## WEST SUSSEX COUNTY COUNCIL CONSULTATION

| <b>LOCATION:</b>                | 5 Hobbs Court, The Potting Barn, Bilsham Road, Yapton, BN18 0JY                                                                                                                                                                            |
| <b>SUBJECT:</b>                 | Y/9/19/HH<br>New crossover to single dwelling.                                                                                                                                                                                             |

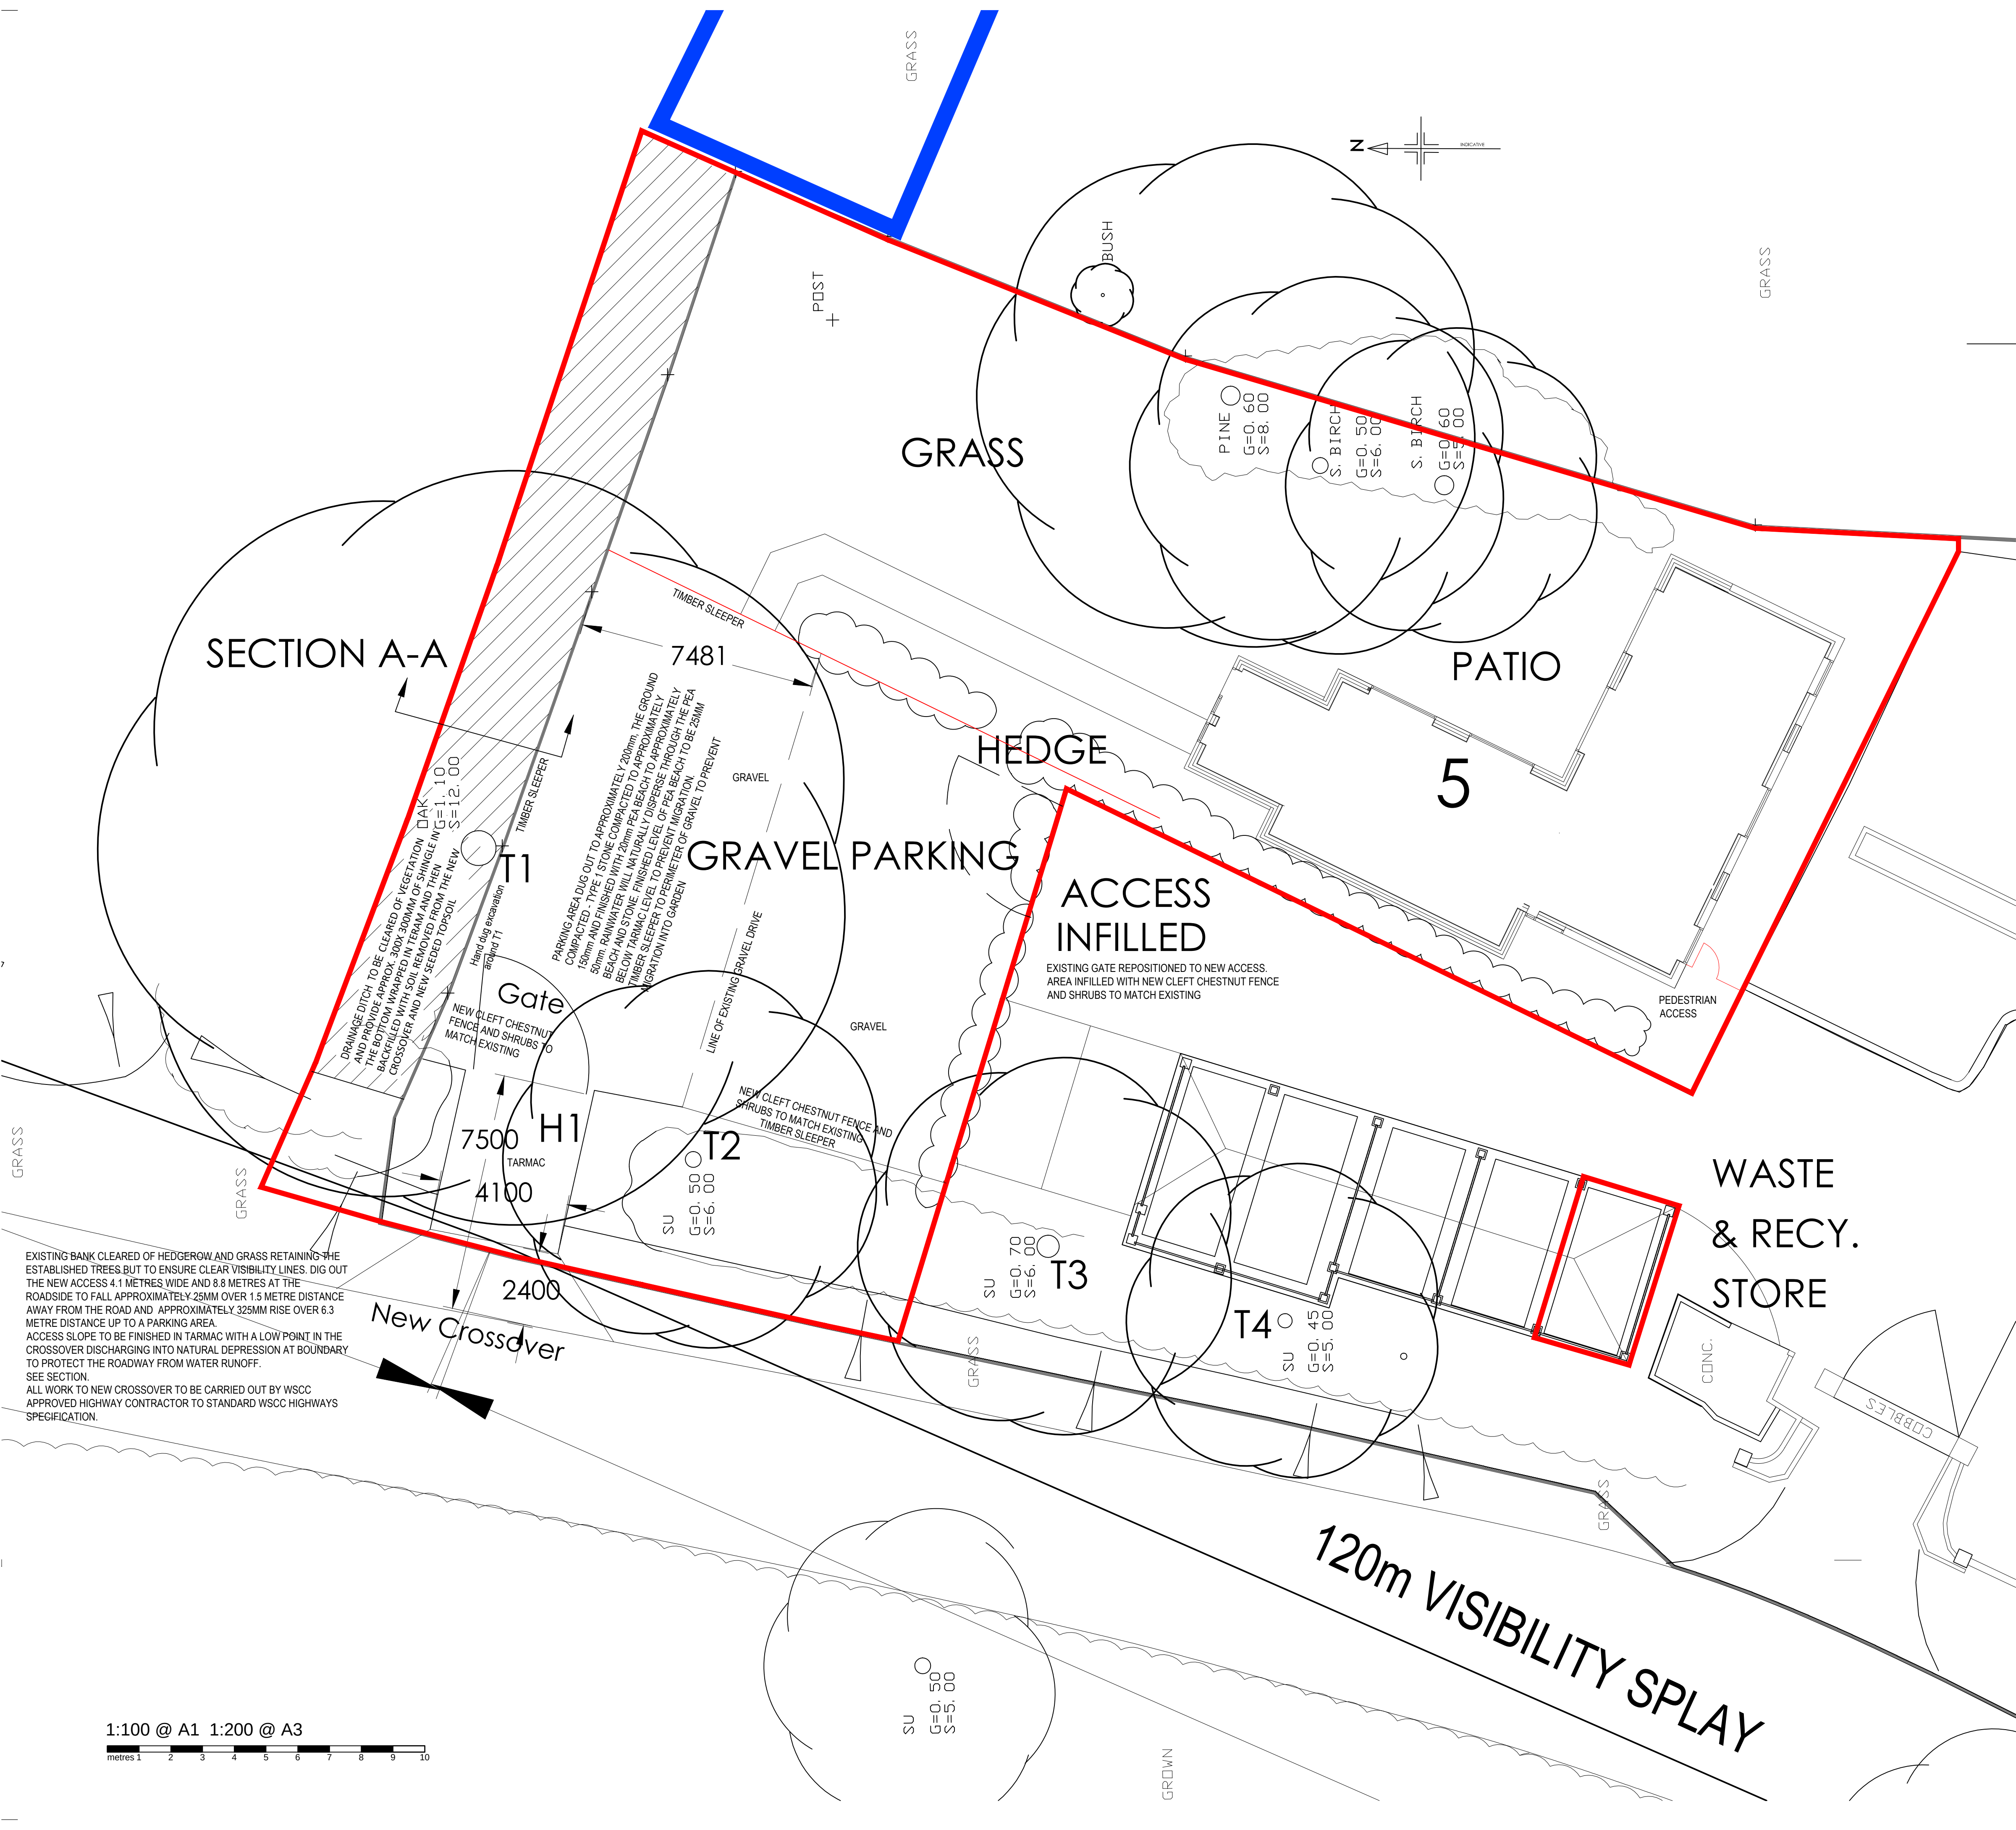
A gate will be erected at the site entrance at a distance of 7.5m from the back edge of the carriageway. The plan indicates that the gate will open inwards of the site to ensure that vehicles do not obstruct the public highway whilst the gate is in operation.

1:500 @ A3 BLOCK PLAN

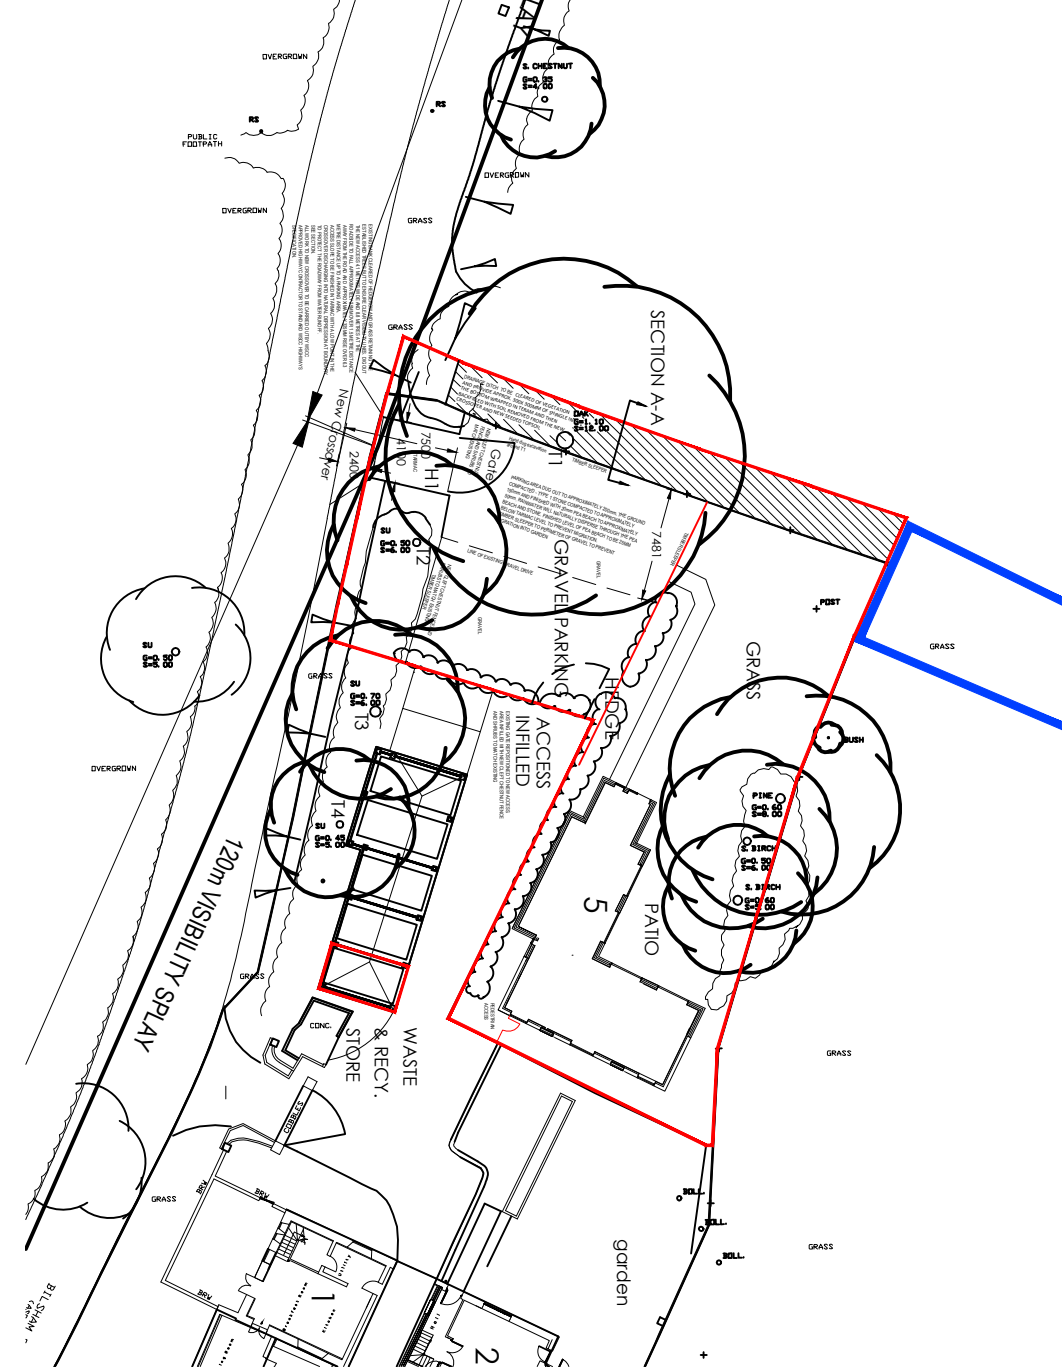
The applicant has provided a visibility splay plan demonstrating splays to 120m in each direction at 2.4m back from the carriageway edge. However the splays to the north of the access utilise land which does not appear to be under the applicants' control or land within the public highway. The applicant should provide revised splays demonstrating that 120m visibility is achievable, utilising land only within

The applicant is requested to demonstrate that 120m visibility is achievable to the north of the proposed access as set out above. If this is unachievable, maximum achievable visibility splays should be demonstrated and supported with a seven day speed survey.
